DECISION DELEGATED TO HEAD OF PLANNING

Application No: H02-0266-24 **Applicant:** Mr & Mrs C Newman

Proposal: Erection of single storey detached dwelling with integral garaging and additional parking provision for existing dwelling (No. 1A Peterborough Road)

Location: Rear Of 1a Peterborough Road Crowland Peterborough

Site Layout as proposed 1:250 scale

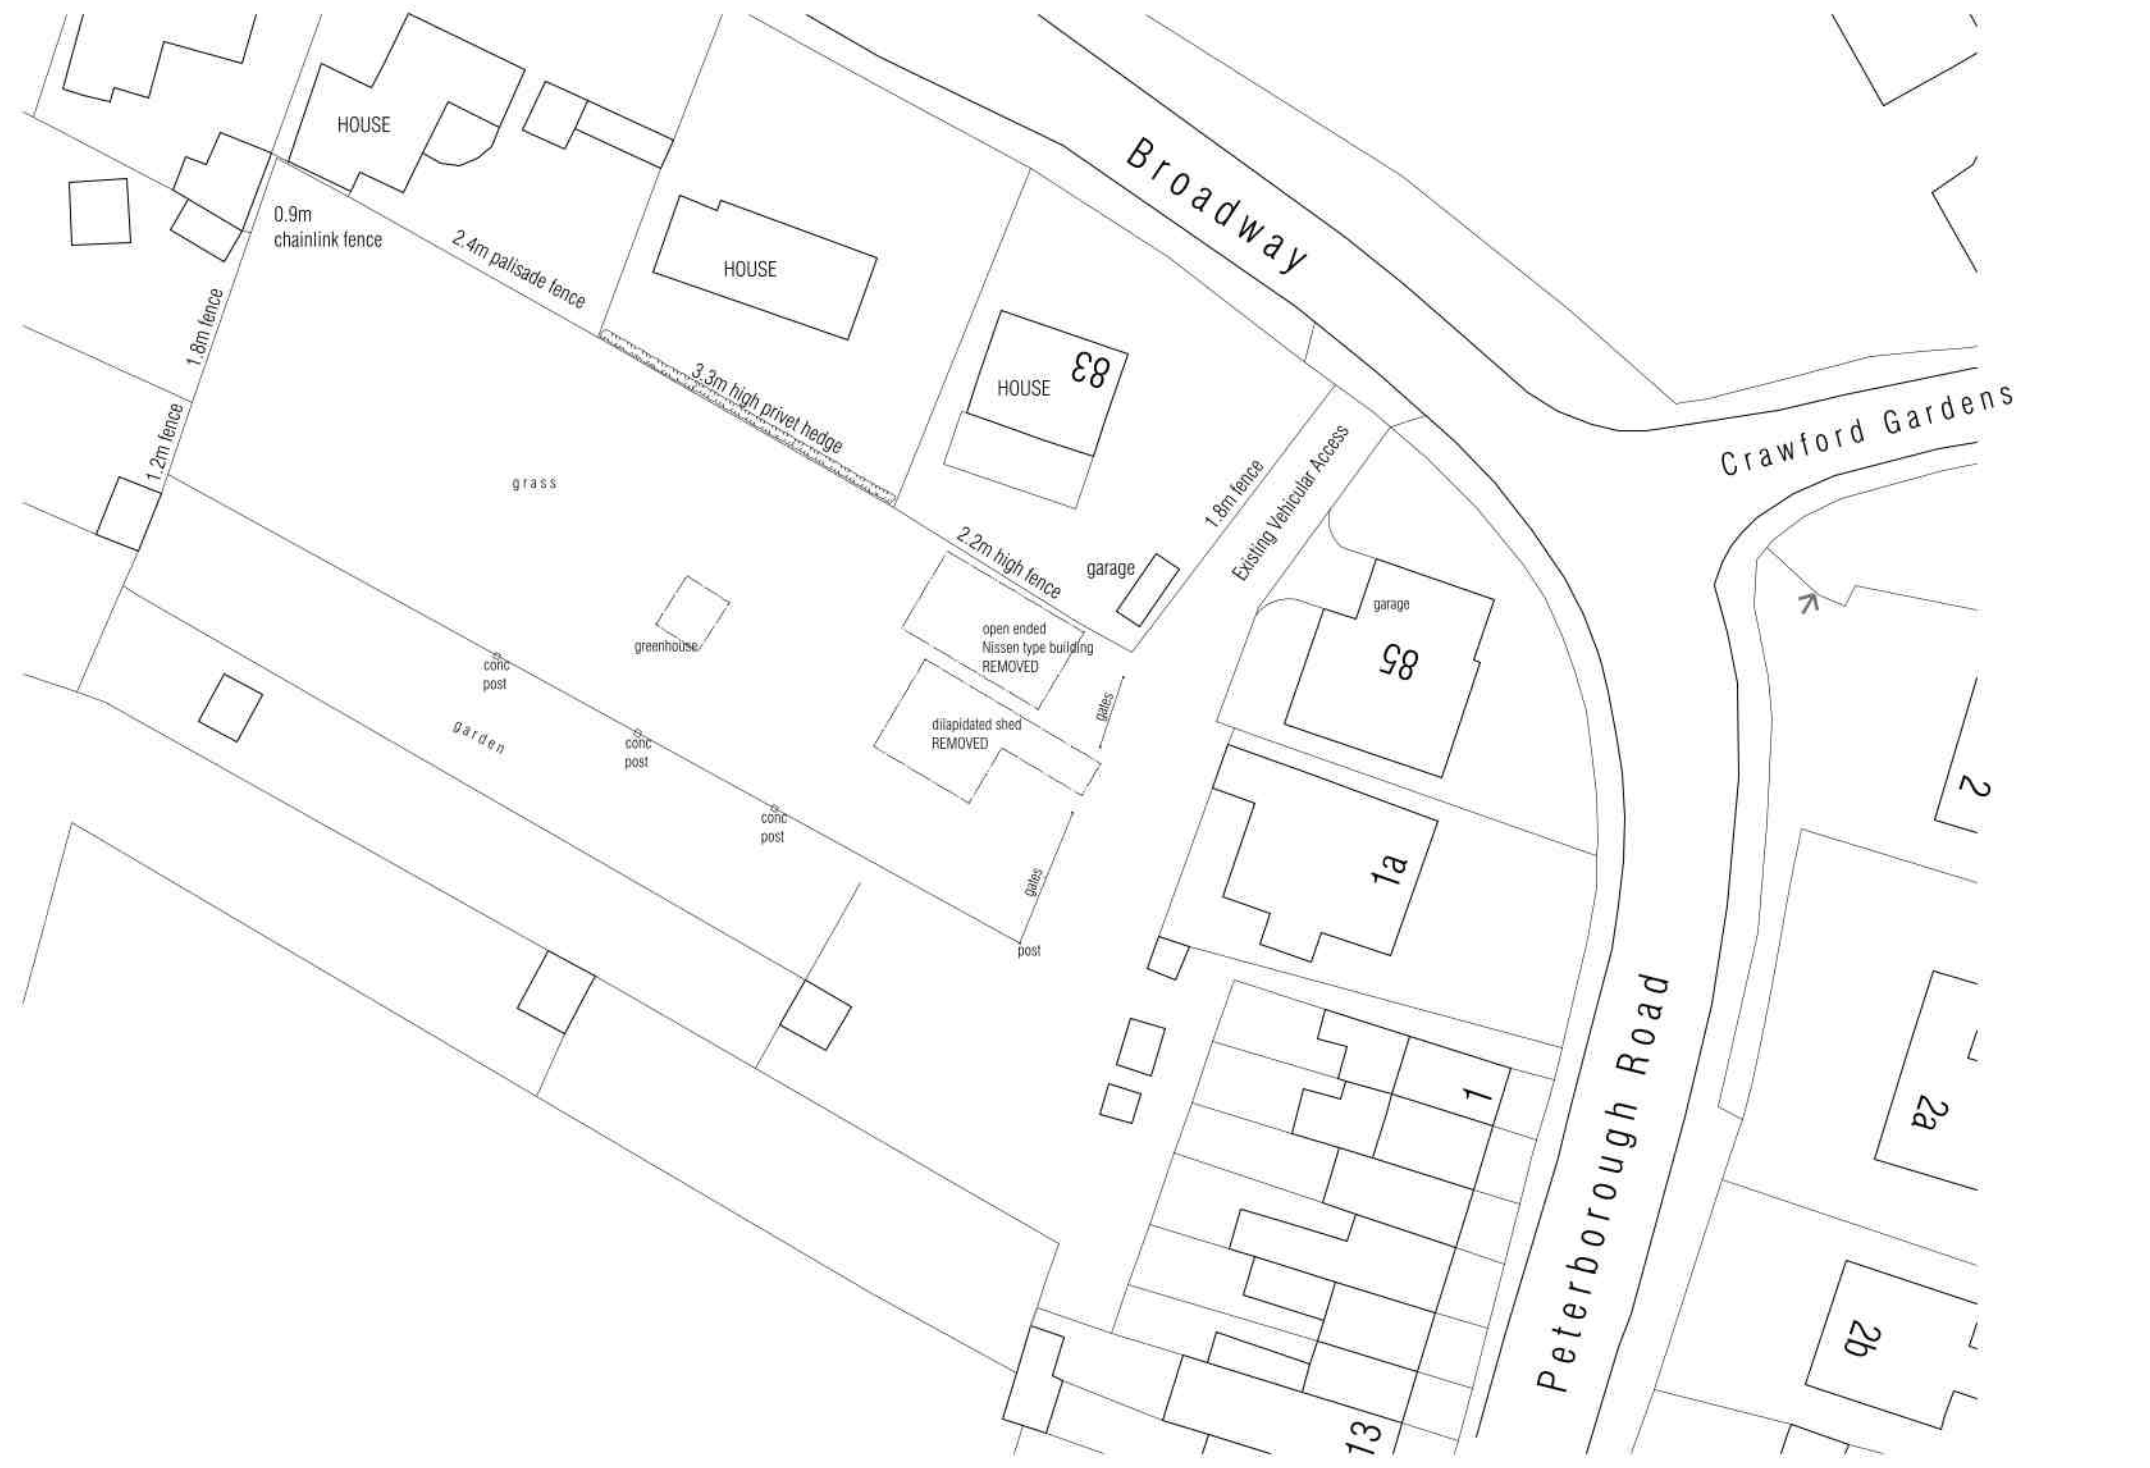
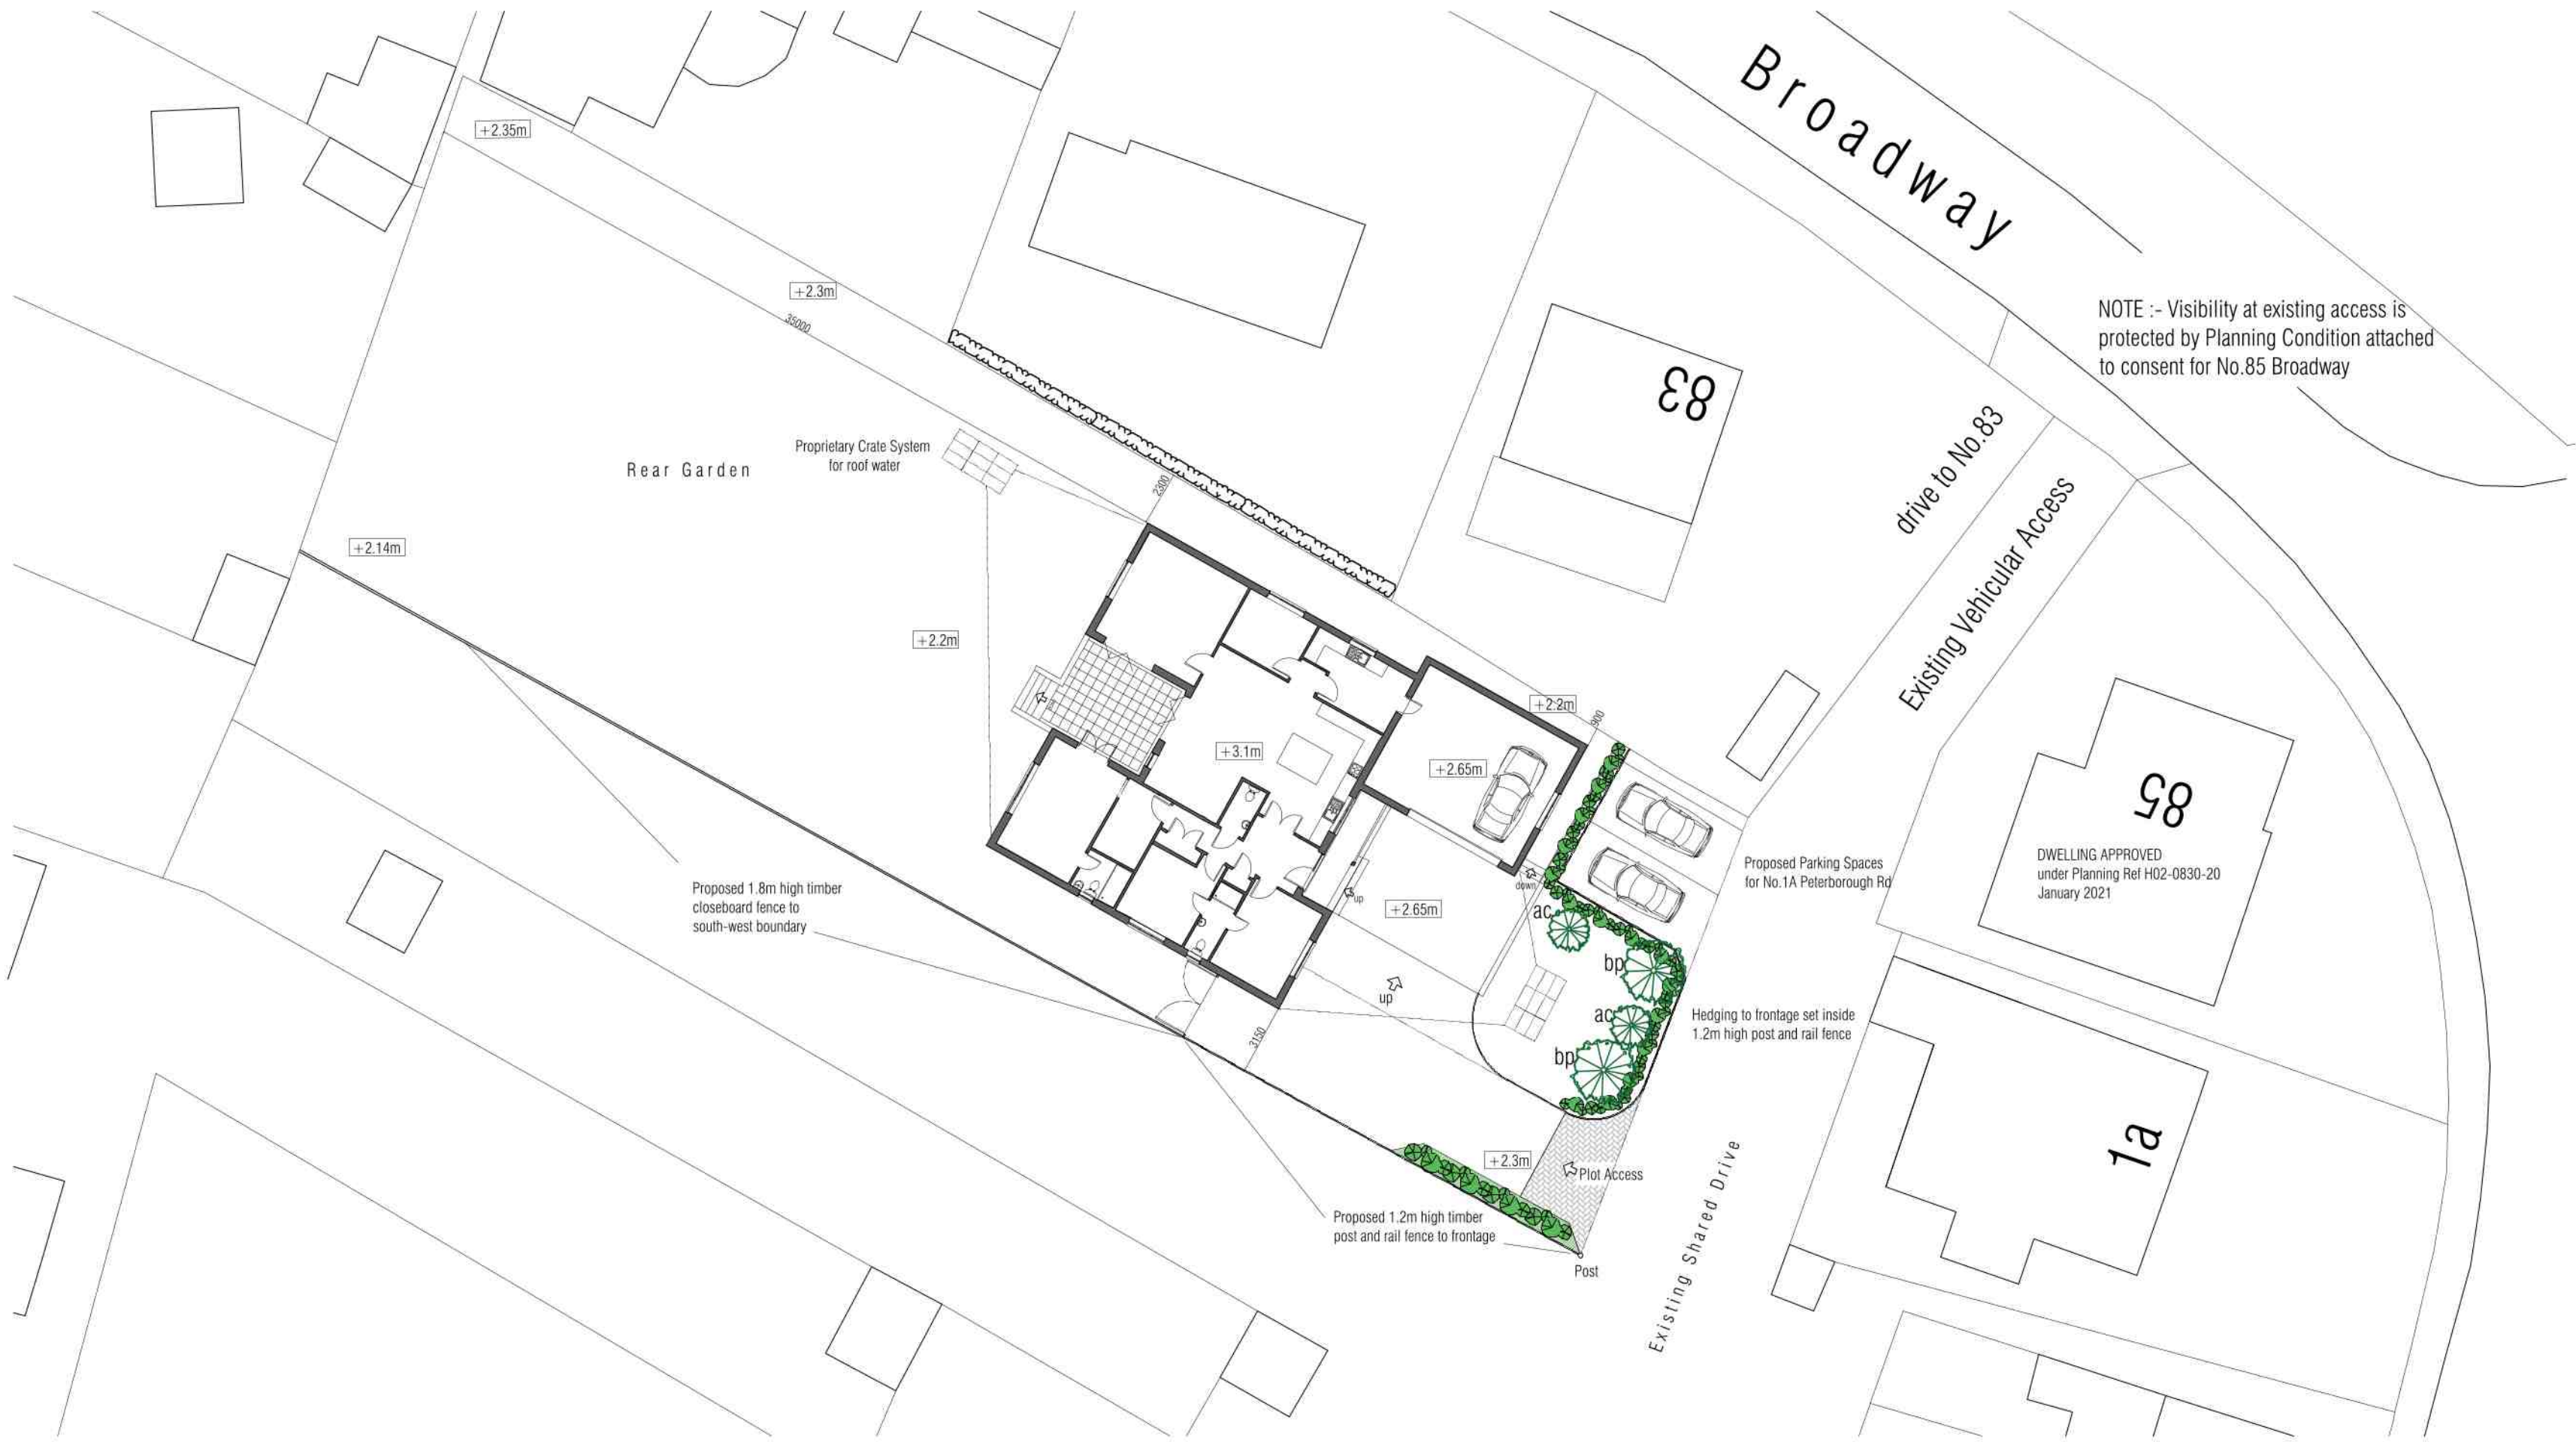
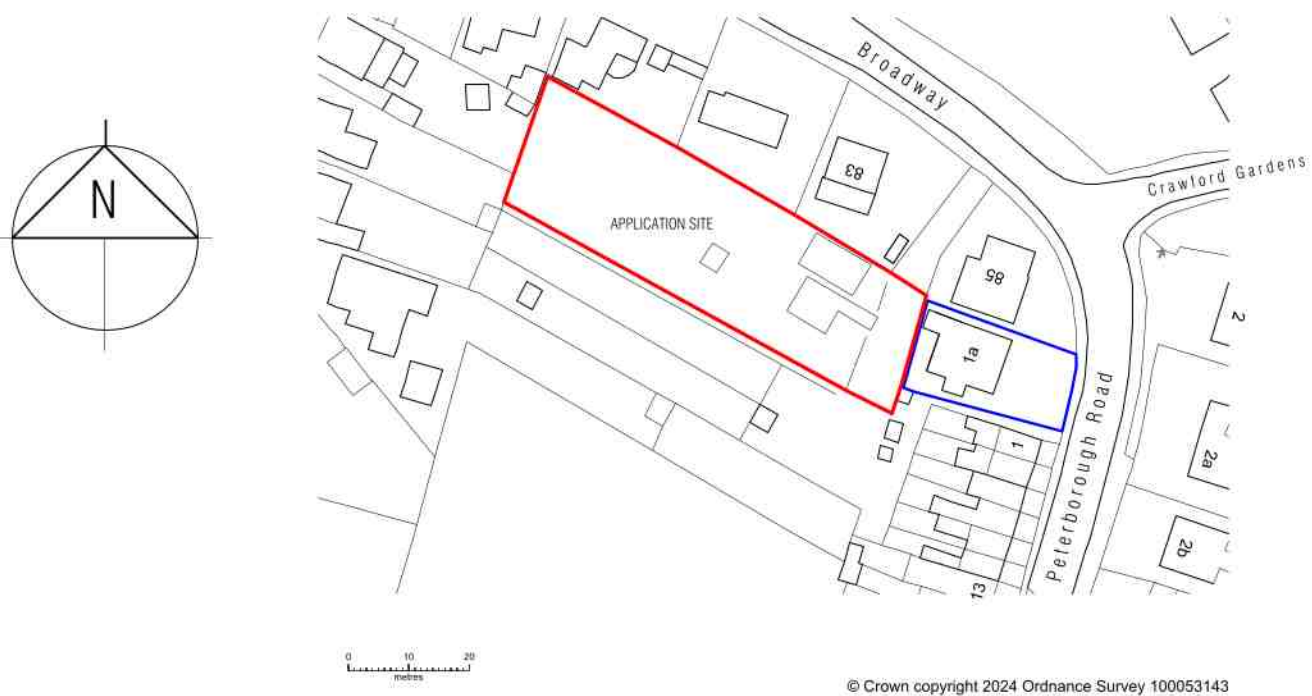
A proposed 1.2 metre high timber post and rail fence is to be sited adjacent to the driveway with hedging behind. A 1.2 metre high post and rail fence with hedging set inside is also positioned along the site frontage. Two parking spaces are to be sited on the frontage for 1a Peterborough Road with four spaces for the new dwelling. The dwelling is to be sited 0.8 metres above ground level at the deepest part of the site.

To provide mains sewerage the applicant would have to dig up the access road which is the sole means of access to the some properties. This would also mean no emergency services access.

A member of the public objection states that to provide mains sewerage the applicant would have to dig up the access road which is the sole means of access to the some properties. This would also mean no emergency services access.

"The proposed development involves the use of a non-mains foul drainage system in circumstances where it may be reasonable for the development to connect to a public sewer, but insufficient justification has been provided for the use of a non-mains system. The nearest Anglian Water sewer network can be found less than 30 metres from the boundary of the proposed site."

"To overcome our objection the applicant should thoroughly investigate the possibility of connecting to the public foul sewer, and either revise their application to propose a mains connection or submit evidence that demonstrates that this is not feasible. If the customer believes they can provide evidence that connecting to the foul sewer is not feasible, we recommend that they submit a fully completed FDA1 Foul Drainage Assessment form to us for review."

There are to be 6 off road parking spaces with cycle storage provision in the garage. Four off road parking spaces will be provided for the new dwelling with two spaces for 1a Peterborough Road on the opposite side of the private access road. There is ample space for manoeuvring and the amount of parking provision accords with Appendix 6 of the SELLP.

Following an amendment by the applicant, connection to the existing foul water drainage is proposed. The Environment Agency has removed it's objection to the proposed foul water drainage provision.
